From: Hannah Riddle on behalf of Planning.Responses
Sent: 25 April 2022 15:38
To: Planning Scanning
Subject: FW: Planning Consultation on: LU/82/22/PD

Application No: LU/82/22/PD

Site Address: 38/40 High Street Littlehampton

Description of Works: Prior notification under Schedule 2, Part 3, Class G for the change of use of upper floors to 2 No flats.

Proposed Ground Floor Plan 1:100

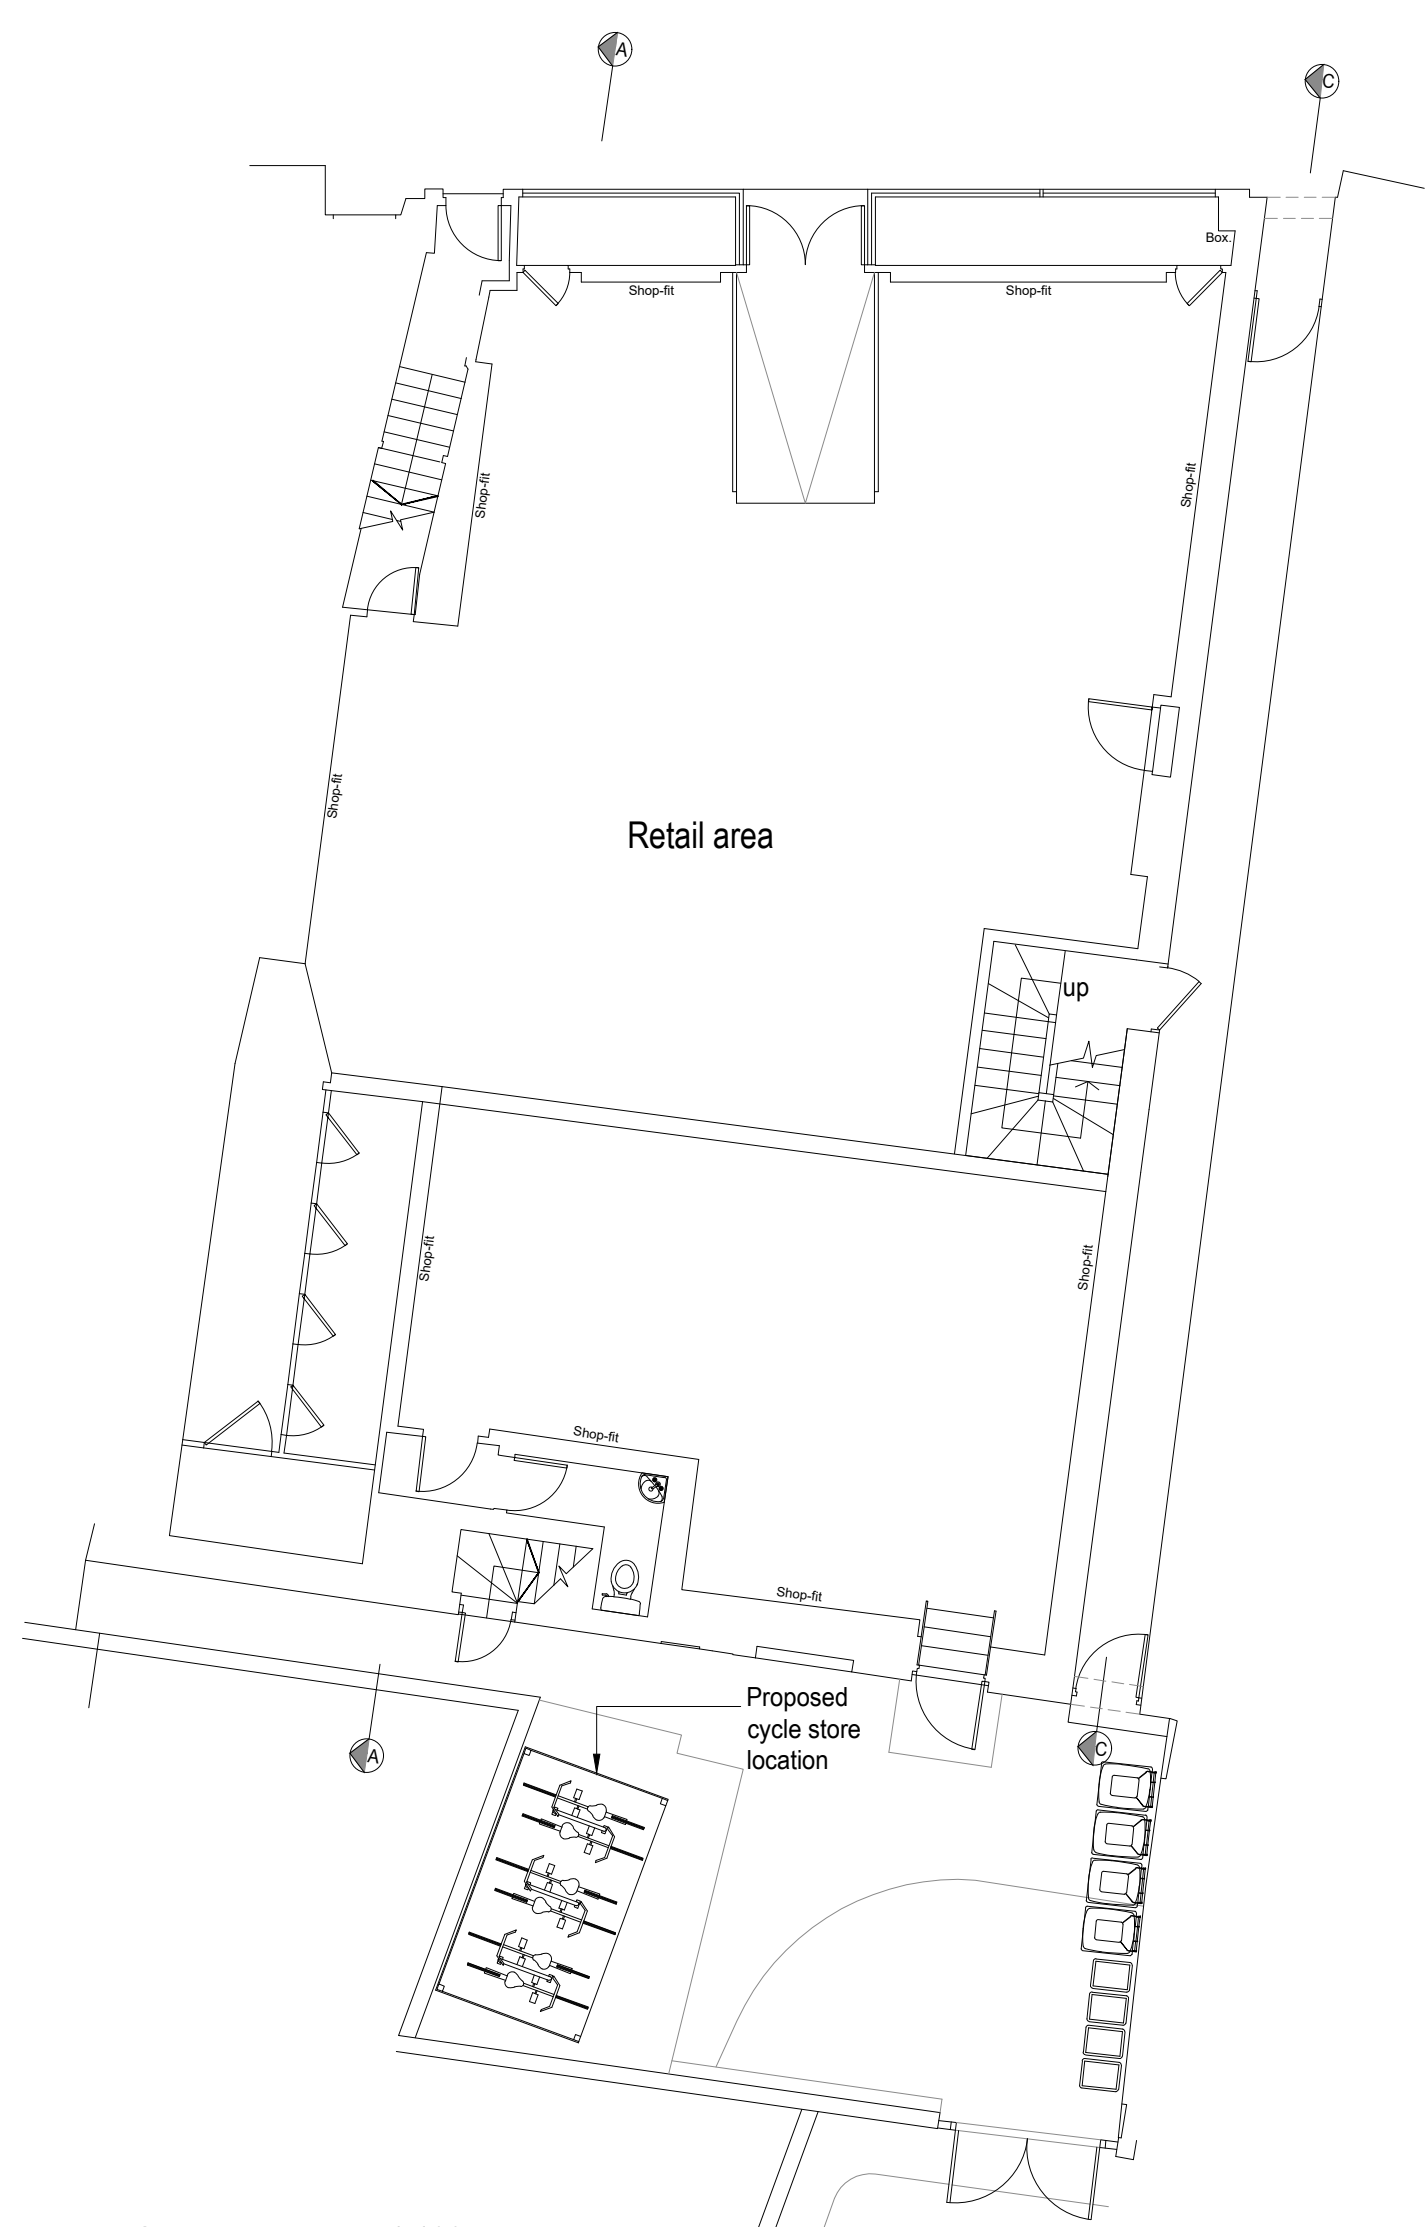
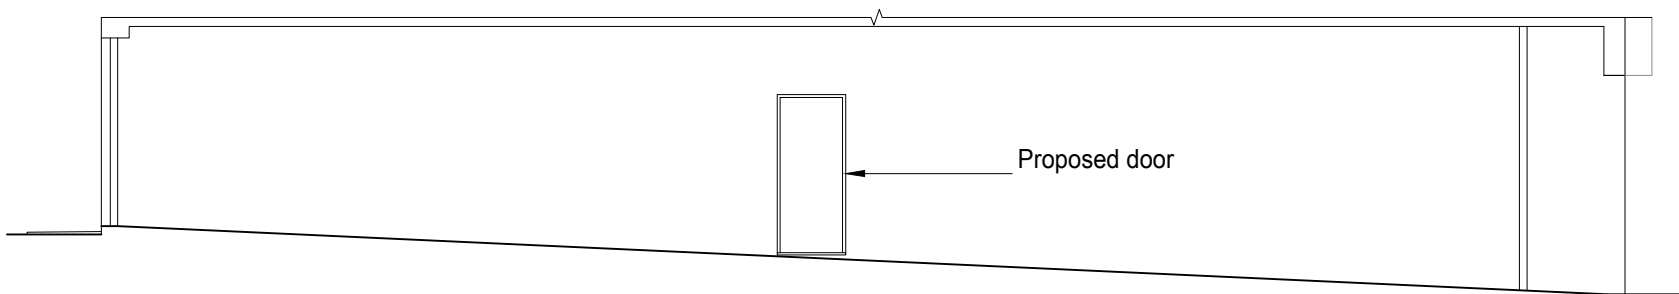
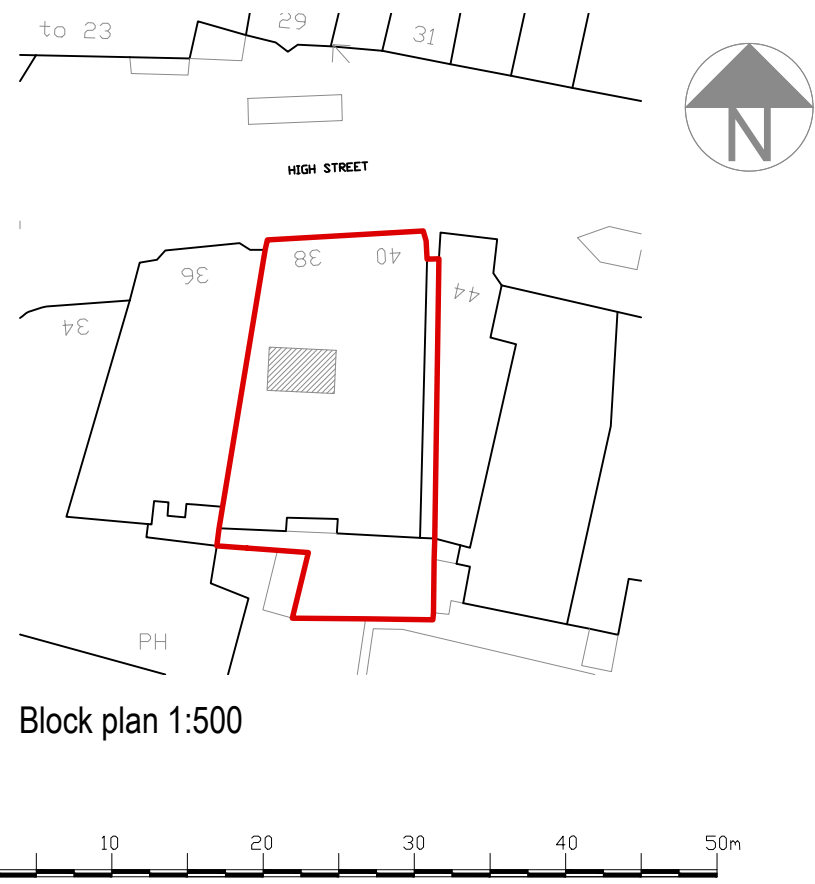
- There should be adequate fire separation (usually 60 minutes) between the commercial unit on the ground floor and the residential flats above
- The internal escape routes should provide 30 minutes fire resistance, including the provision of 30-minute fire resisting and self-closing fire doors (FD30S) to each unit entrance

- The staircase serving the first floor within unit 1 appears to have an understairs cupboard accessed via the retail unit. As a minimum, this staircase should be underdrawn with appropriate fire resistant materials to protect the means of escape. If the cupboard houses any sources of ignition, the entire cupboard will need to afford appropriate fire resistance; it may also be necessary to install an interlinked Grade A detector within the cupboard

- The staircase serving the second floor within unit 2 runs above the ensuite bathroom serving the first floor north-facing bedroom. As a minimum, this staircase should be underdrawn with appropriate fire resistant materials to protect the means of escape

- The proposed second floor communal bathroom located nearest to the staircase does not appear to be of an adequate size or layout. Bathrooms must be of an appropriate size to provide adequate changing and drying space for the user. From the proposed plans, it seems likely the users would collide with either the walls and/or the amenities within the bathrooms. In addition, this could be identified as a hazard under the Housing Health and Safety Rating System (HHSRS). Consideration should be given to reconfiguring the bathroom

- All the ensuite bathrooms, possibly with the exception of one, also appear to be inadequate in terms of size and layout. The bathrooms in question appear to be of the same width as the shower cubicle which looks to be very narrow, potentially creating the same issues highlighted with the communal bathroom, above. In addition, some of the ensuite bathrooms appear to only provide a shower cubicle and WC with no wash hand basin. A wash hand basin must be installed within the same room as a WC. Consideration should be given to reconfiguring the ensuite bathrooms
